**RE: APS Rankin Training Facility
Grading and Drainage Plan
Engineer's Stamp Date 2-16-2016 (File:G15D061)**

Project Title: Rankin Training Facility Site Renovations Building Permit #: T201390019 City Drainage #: G15D061

Re: Rankin Training Facility
720 Rankin Rd., NE
Traffic Circulation Layout
Engineer's/Architect's Stamp dated 3-9-16 (G15-D061)

Re: Rankin Training Facility
720 Rankin Rd., NE
Traffic Circulation Layout *DO 61*
Engineer's/Architect's Stamp **3-9-16** (G15-~~D0641~~)

C-101R

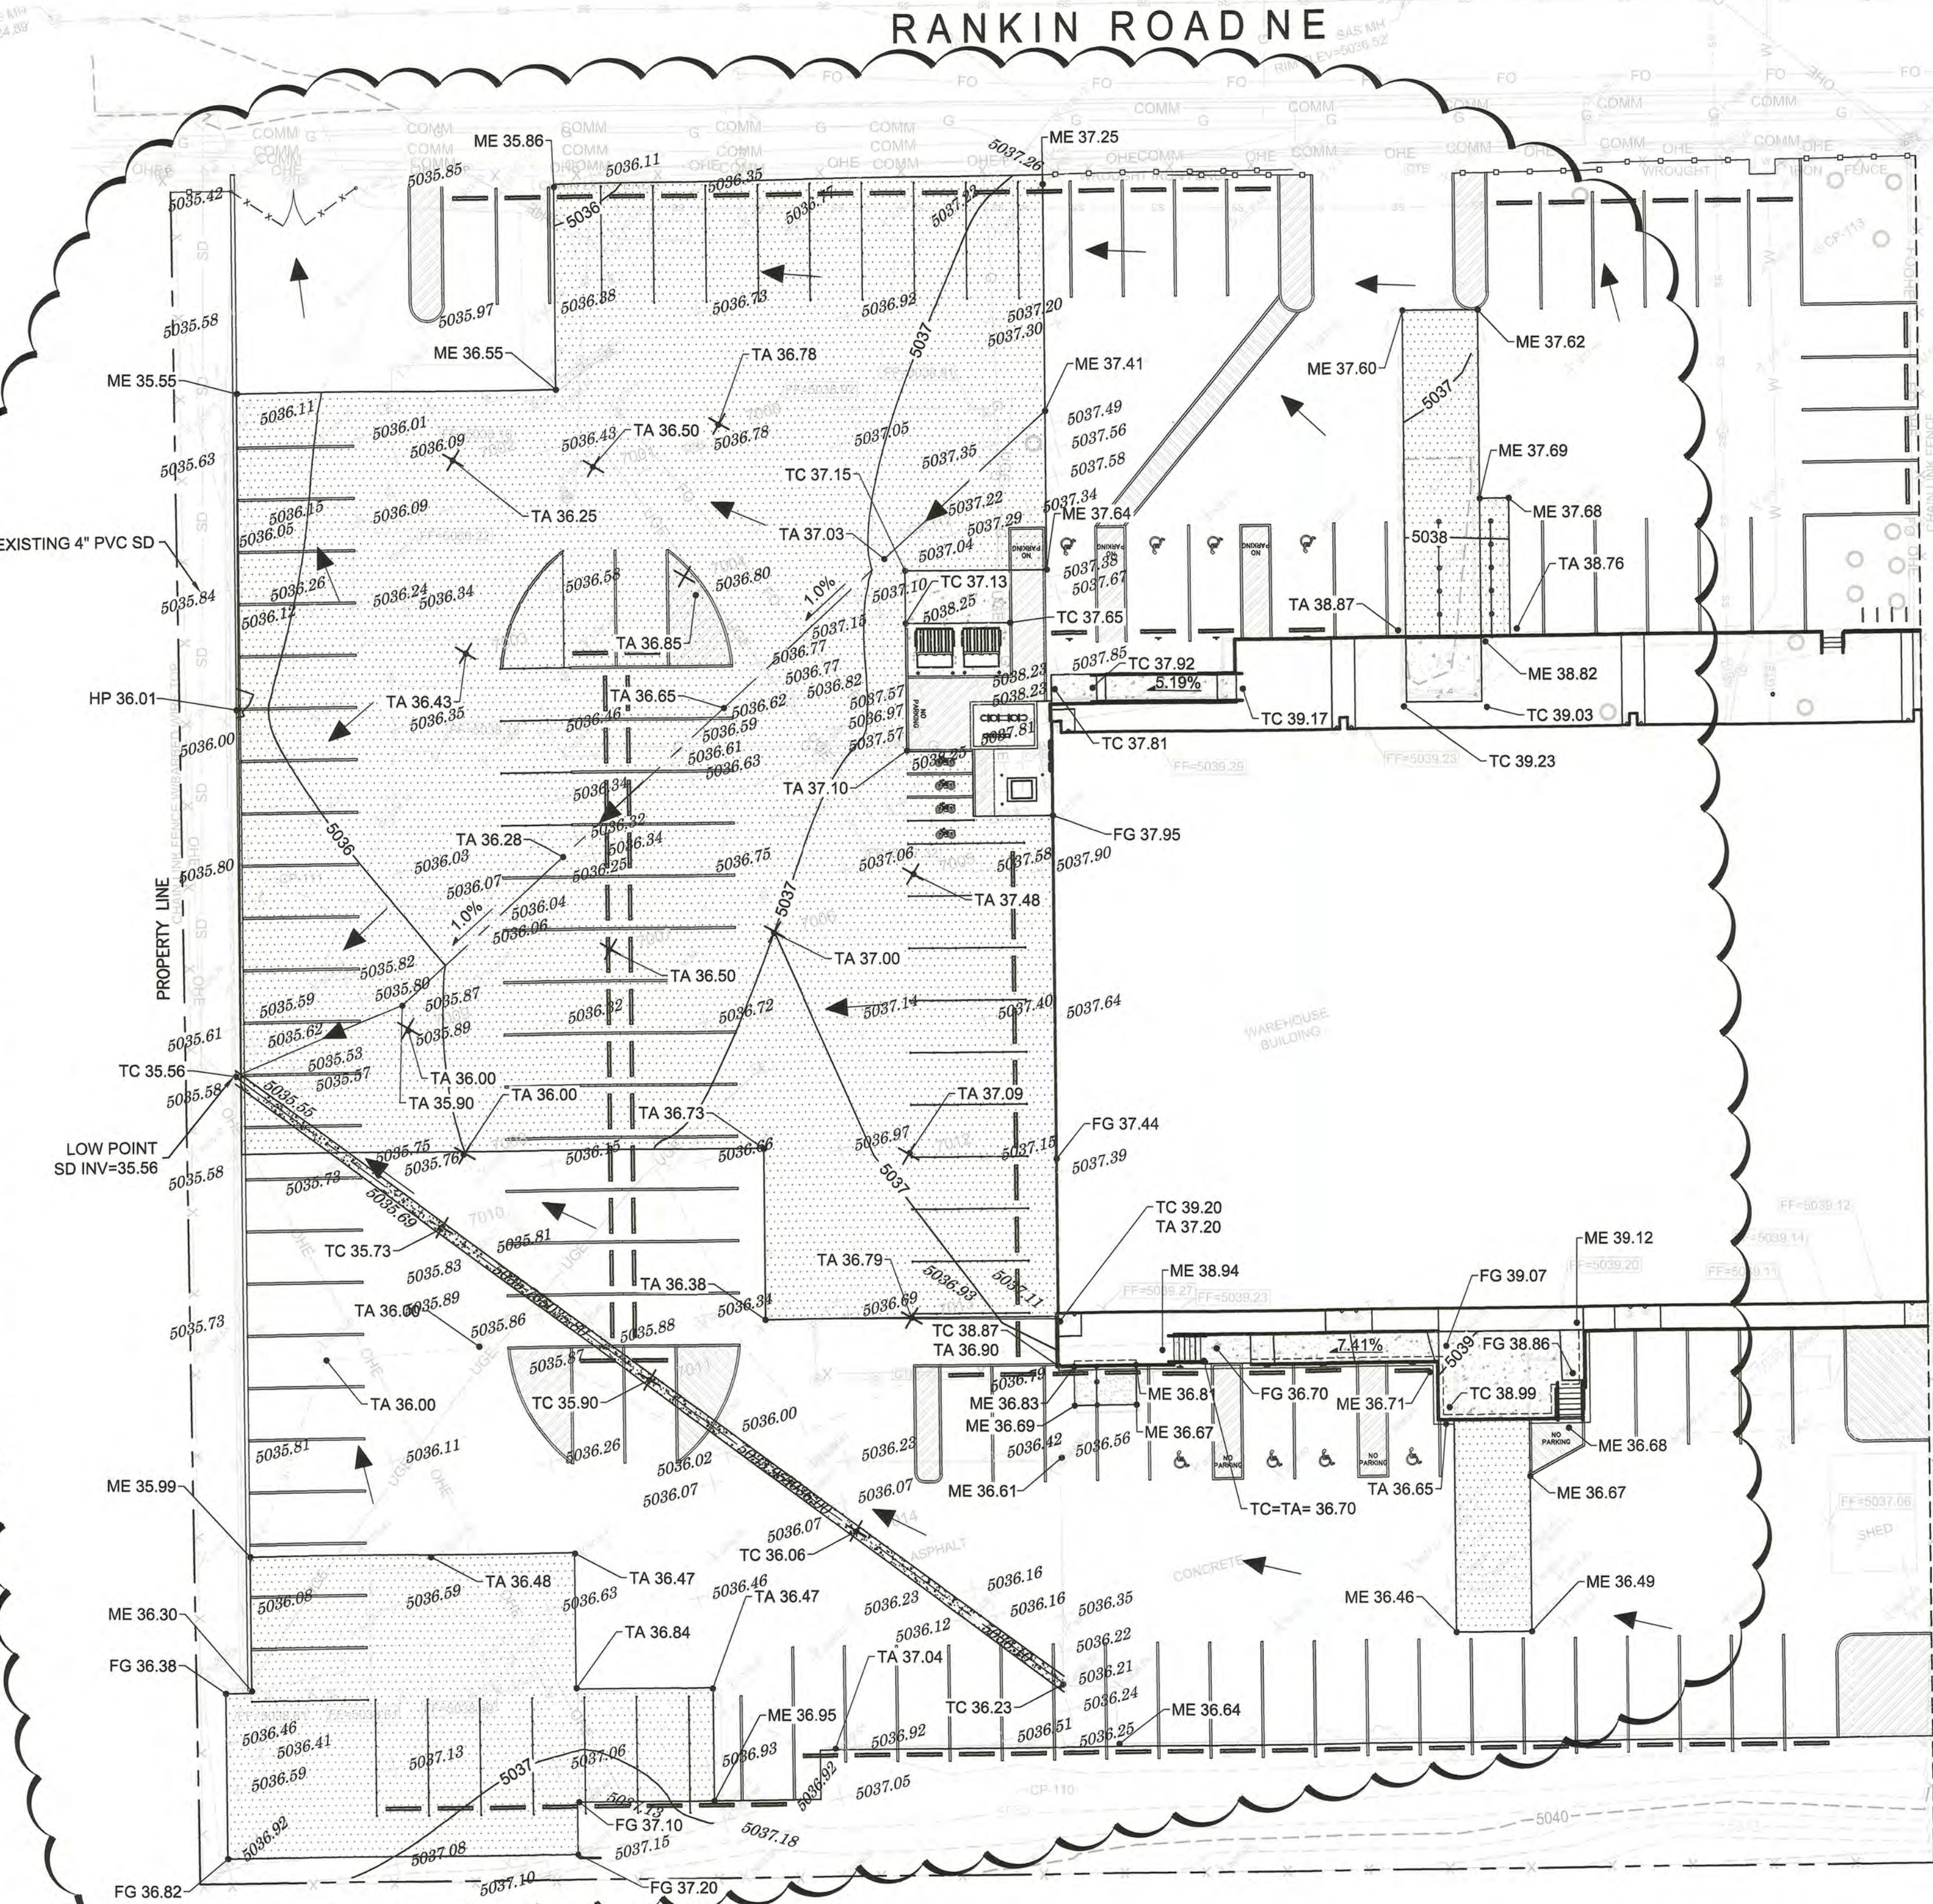
1. The crusher fine parking areas should be graded away from the pavement edges, or the pavement section will be subject to subgrade failure and eventual edge cracking. This will be a requirement, if during the C.O. inspection it becomes apparent that sediment will wash onto the street during a storm.
2. A cut-off wall (or narrow edge curbing) should be considered to maintain the integrity of the new edges of asphalt.

B2 TRAFFIC CIRCULATION LAYOUT PLAN
1"= 20'-0"

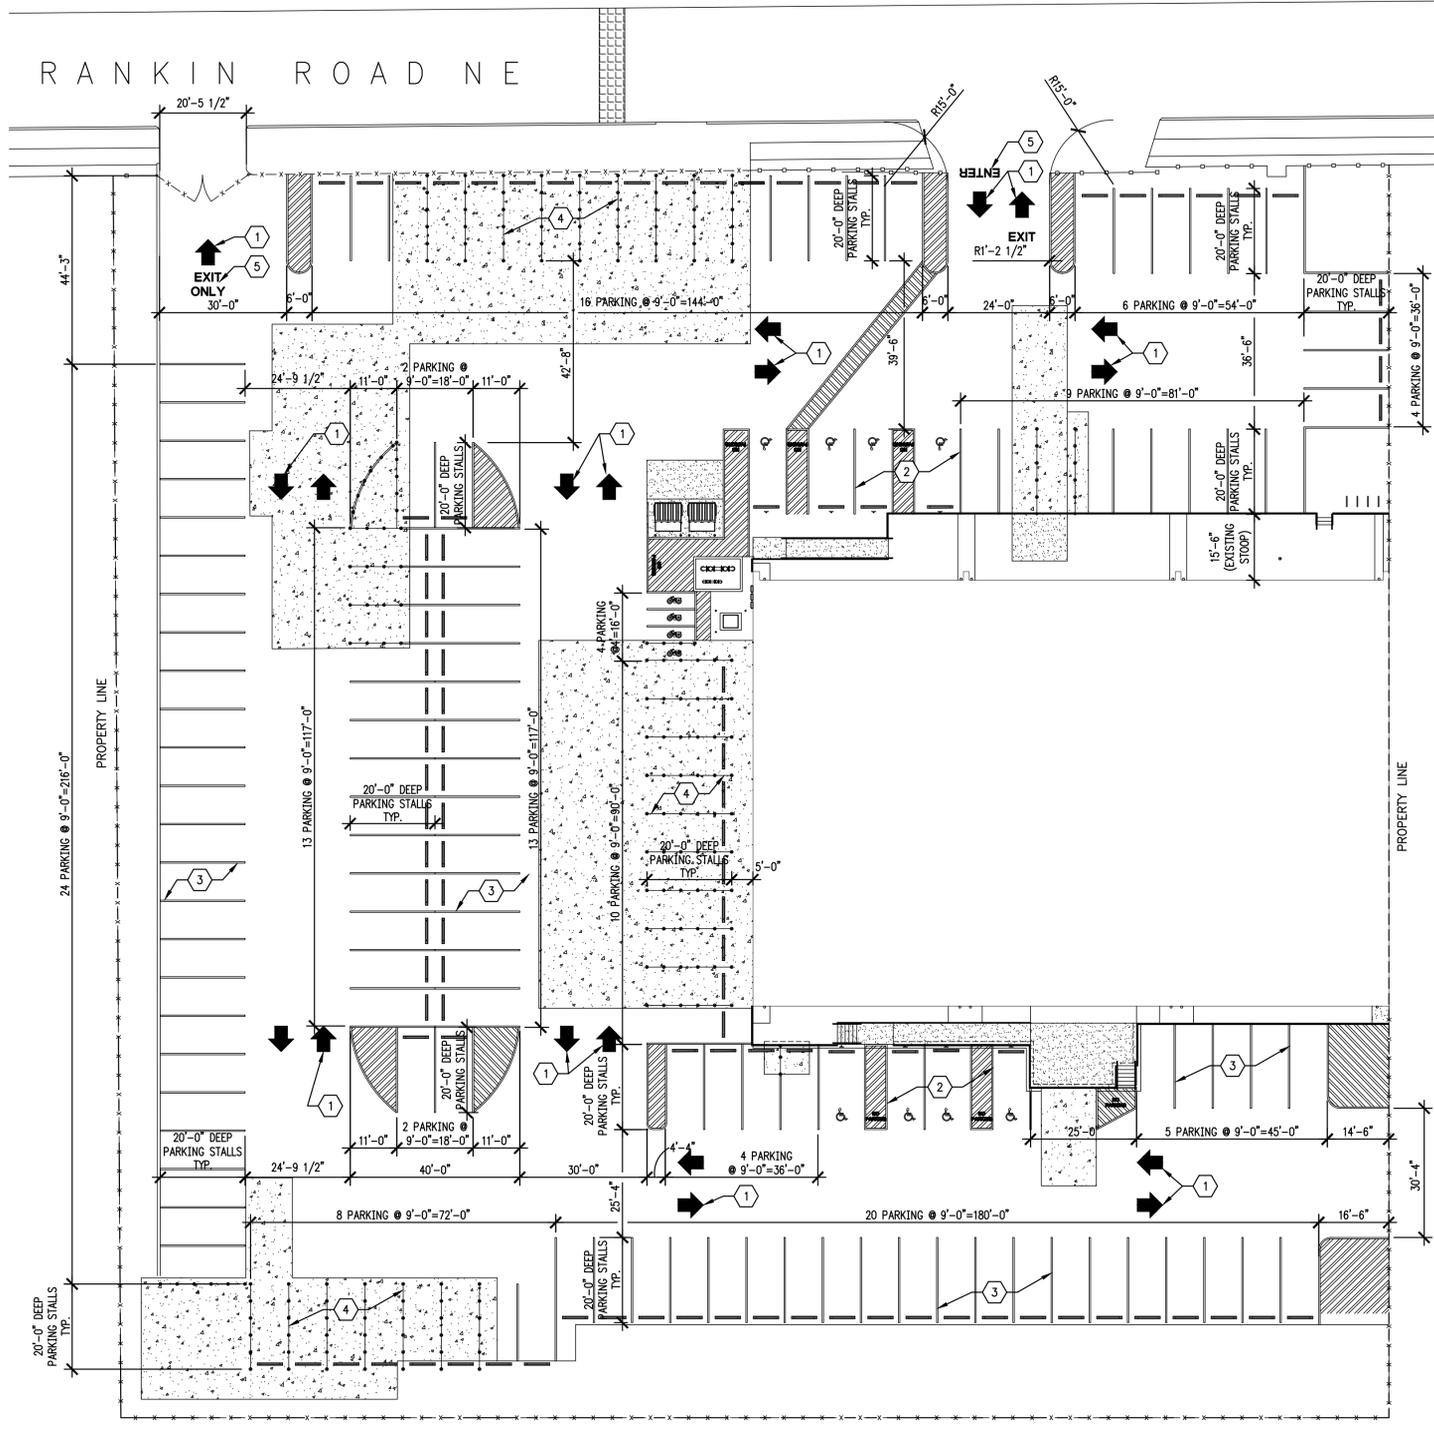
1. Please show a vicinity map showing the location of the development in relation to streets and well known landmarks.
2. List the number of parking spaces required by the zoning code as well as the proposed number of parking spaces.

3. Clarify the extents of the current phase.
4. Please identify and dimension all existing buildings, doors, structures, sidewalks, ADA ramps, curbs, drive pads, wall and anything that influences the parking and circulation on the site.

5. Identify all existing access easements and rights of way width dimensions.
6. Identify the right of way width, medians, curb cuts, and street widths on Rankin Rd.

7. Please list the width and length for all existing and proposed parking spaces. Dimension all HC parking spaces and HC Access Isles.
8. The handicap accessible spaces must include an 8 ft. wide van access aisle; all other aisles should be 5 ft. in width.

9. The ADA accessible parking sign must have the required language per 66-7-352.4C NMSA 1978 **"Violators Are Subject to a Fine and/or Towing."** Please call out detail and location of HC signs. Please show a detail of HC signs.

10. Show all drive aisle widths and radii.
11. Per DPM, a 6 ft. wide ADA accessible pedestrian pathway is required from the public sidewalk to the building entrances. Please clearly show this pathway and provide details and dimensions at the drive pad crossing.

12. Per DPM, a 6 ft. wide ADA accessible pedestrian pathway is required from the HC parking stall access aisles to the building entrances. Please clearly show this pathway and provide details from both HC parking locations.

13. Provide a min 6" or max 8" high concrete barrier curb or other acceptable barrier between landscaping and parking areas and/or drive aisles. Please call out detail and location of barrier curb.

14. Design delivery vehicle route needs to be shown.
15. Service vehicle and/or refuse vehicle maneuvering must be contained on-site; provide a copy of refuse approval. Please provide detail of refuse container.

16. One-way vehicular paths require pavement directional signage and a posted "**Do Not Enter**" sign at the point of egress. Please show detail and location of posted signs.

17. It is not apparent what type of pavement surface is being proposed. A hard driving surface will be required as part of this proposed project for parking area and drive aisles.

18. Please provide a sight distance exhibit (see the *Development Process Manual, Chapter 23, Section 3*). Please provide this detail for both entrances/exits on Rankin Rd.

19. Please add the following note to the clear sight triangle: "Landscaping and signage will not interfere with clear sight requirements. Therefore, signs, walls, trees, and shrubbery between 3 and 8 feet tall (as measured from the gutter pan) will not be acceptable in this area."

20. Please specify the City Standard Drawing Number when applicable.
21. Please add a note on the plan stating "All improvements located in the Right of Way must be included on the work order."

22. Unused curb cuts must be replaced with sidewalk and curb & gutter. A build note must be provided referring to the appropriate City Standard drawing.

23. All broken or cracked sidewalk must be replaced with sidewalk and curb & gutter. A build note must be provided referring to the appropriate City Standard drawing.
